NSW Planning Assessment Commission Determination Report

State Significant Development Application and Modification Request for a Project Approval Block 1, Central Park (SSD 6554 and MP 08_0253 MOD 5)

Title
Block 1
External Wall System
Balcony
Cladding Type B

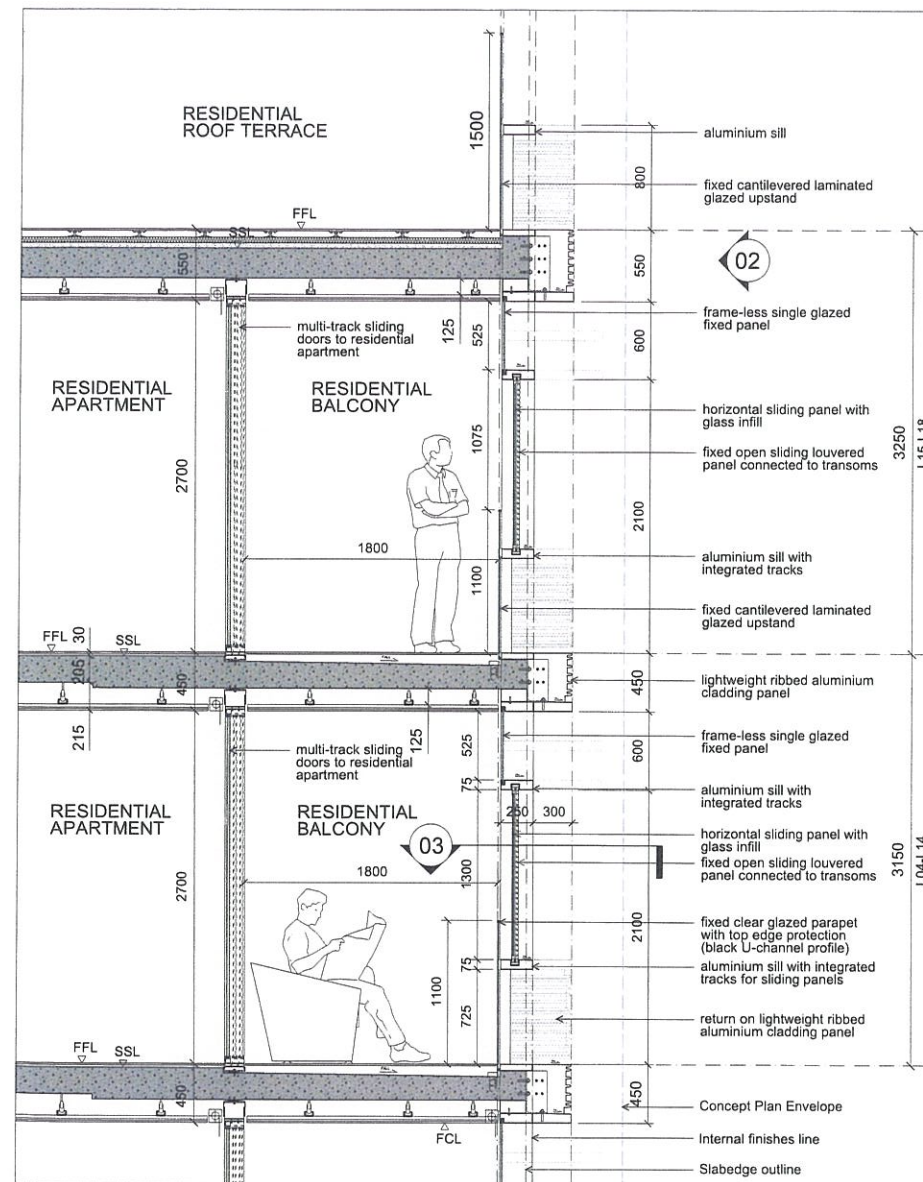
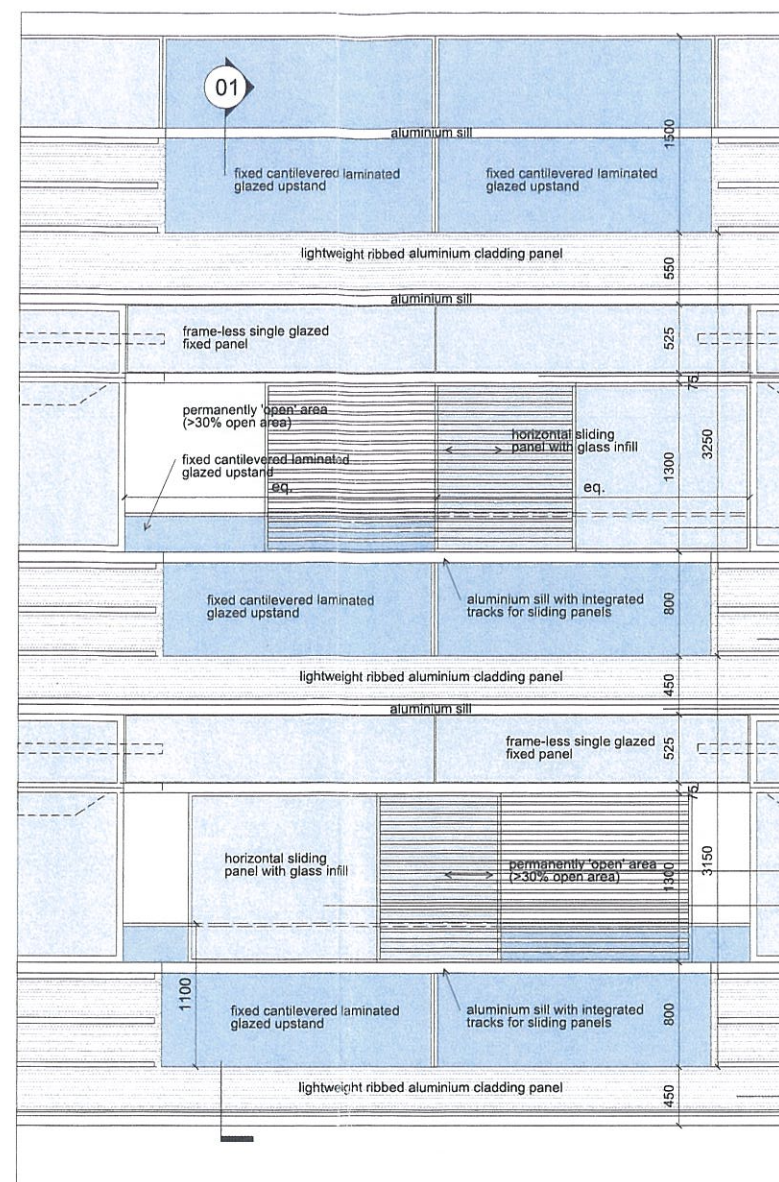
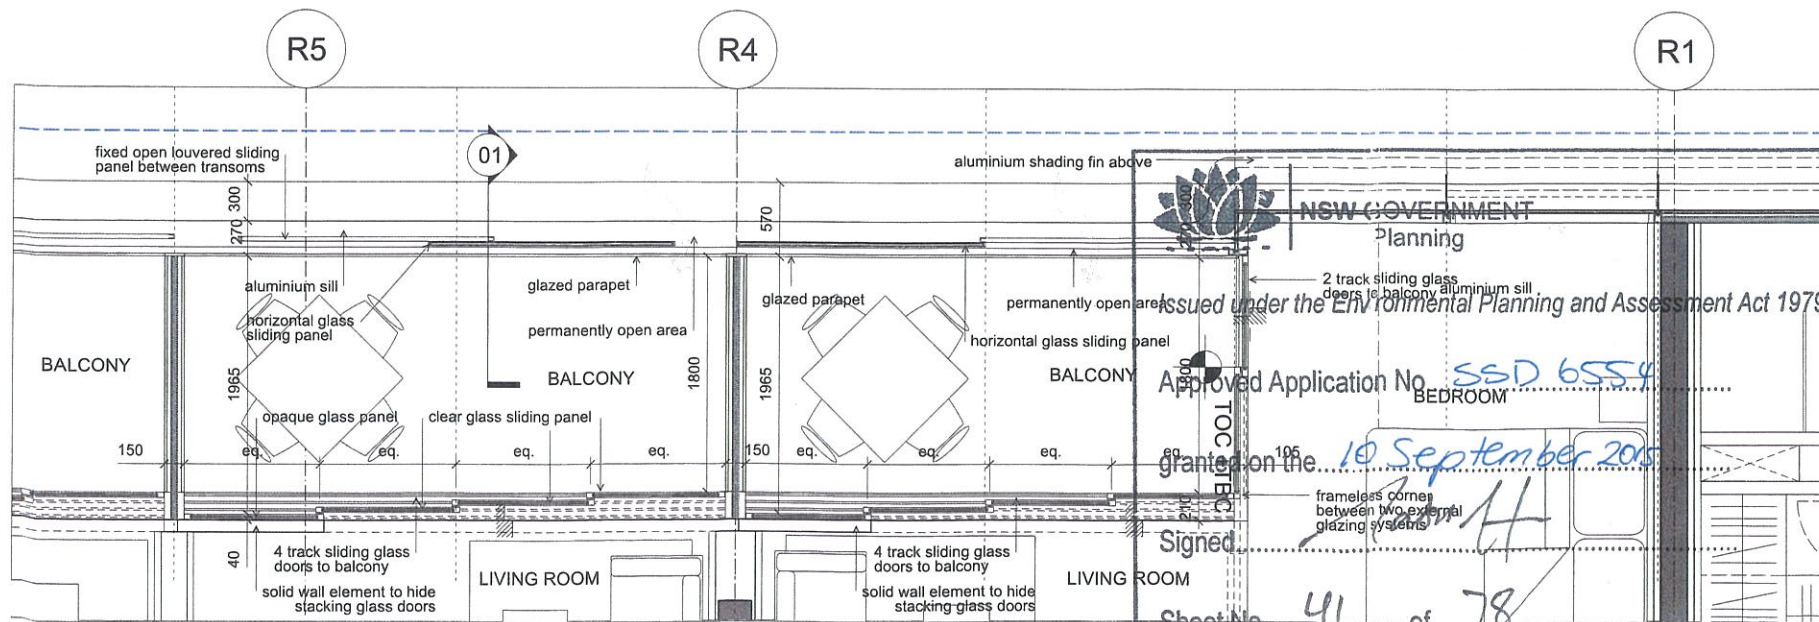
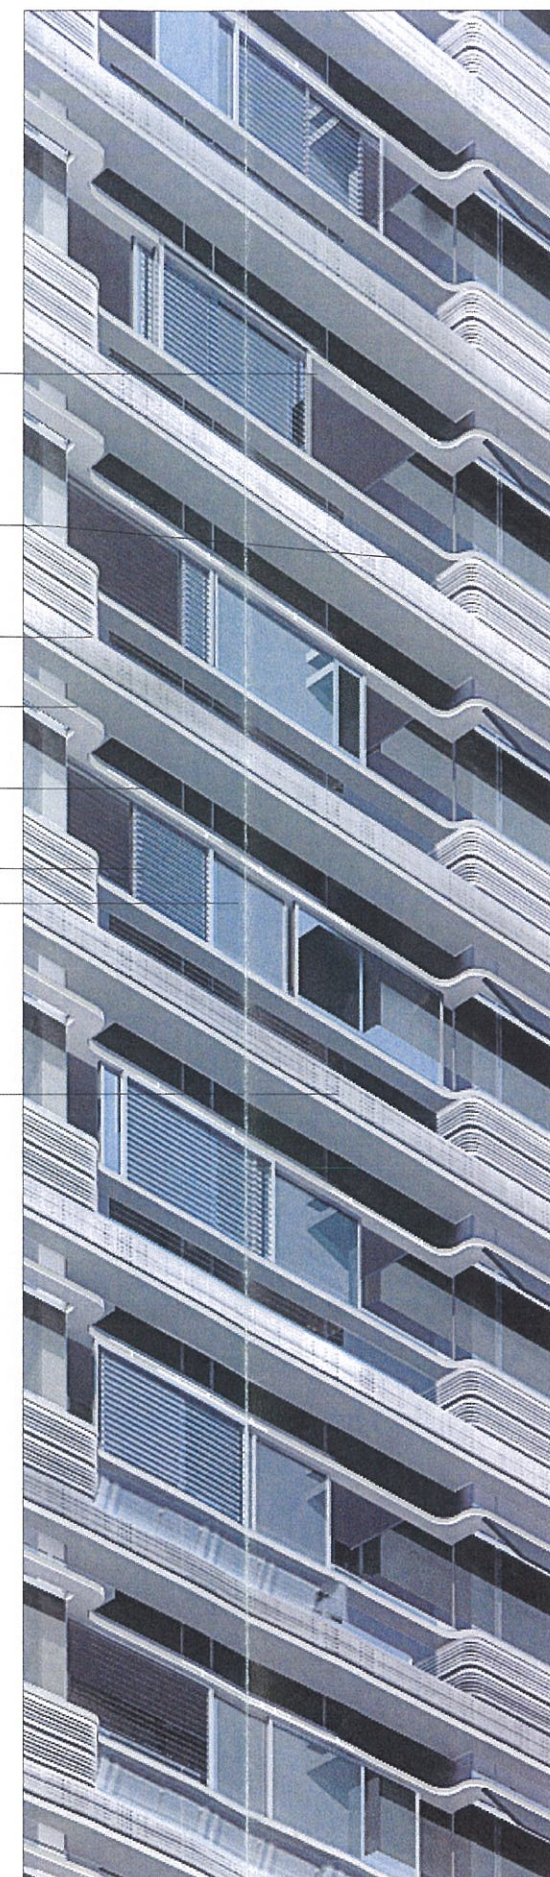
The Department notes that the Residential Flat Design Code (RFDC) recommends that primary balconies should have a minimum depth of 2 metres. The Applicant proposes balconies of 1.8m in some apartments. The Department has therefore recommended a condition that all balconies are increased in depth to 2m by reducing space within the living areas.

The Commission notes that there is ambiguity about how balcony depths are measured (including whether the measurement is from the inside of the glass sliding door or the outside of the glass sliding door). The Commission believes that the proposed design solution of stack doors overcomes the depth concern as the balconies will be provided at grade opening directly to living areas. This facilitates maximum flexibility as the stack doors allow the opening to the balcony to be at almost the full length of the opening. Residents can therefore select to have much wider balcony space if they desire or maximise the indoor space if the sliding doors are closed.

Given the inner city location of this development it is the Commission's opinion that the living space will be a more valuable area for occupants if the design as proposed is approved. Furthermore, the proposed design measures makes the balconies feel more spacious and allow for easier transition between the two spaces (indoor and outdoor). Therefore the Department's recommended condition regarding the minimum 2m depth of balconies has not been adopted.

- ~~c) *Increase the width of all 1.8 meter wide balconies and loggias to a minimum width of 2.0 metres, by converting internal floor spaces to balcony space;*~~
~~*Amendments to apartment layouts so that internal studies without direct access to a window for light and ventilation have a floor area less than 8m²; and*~~
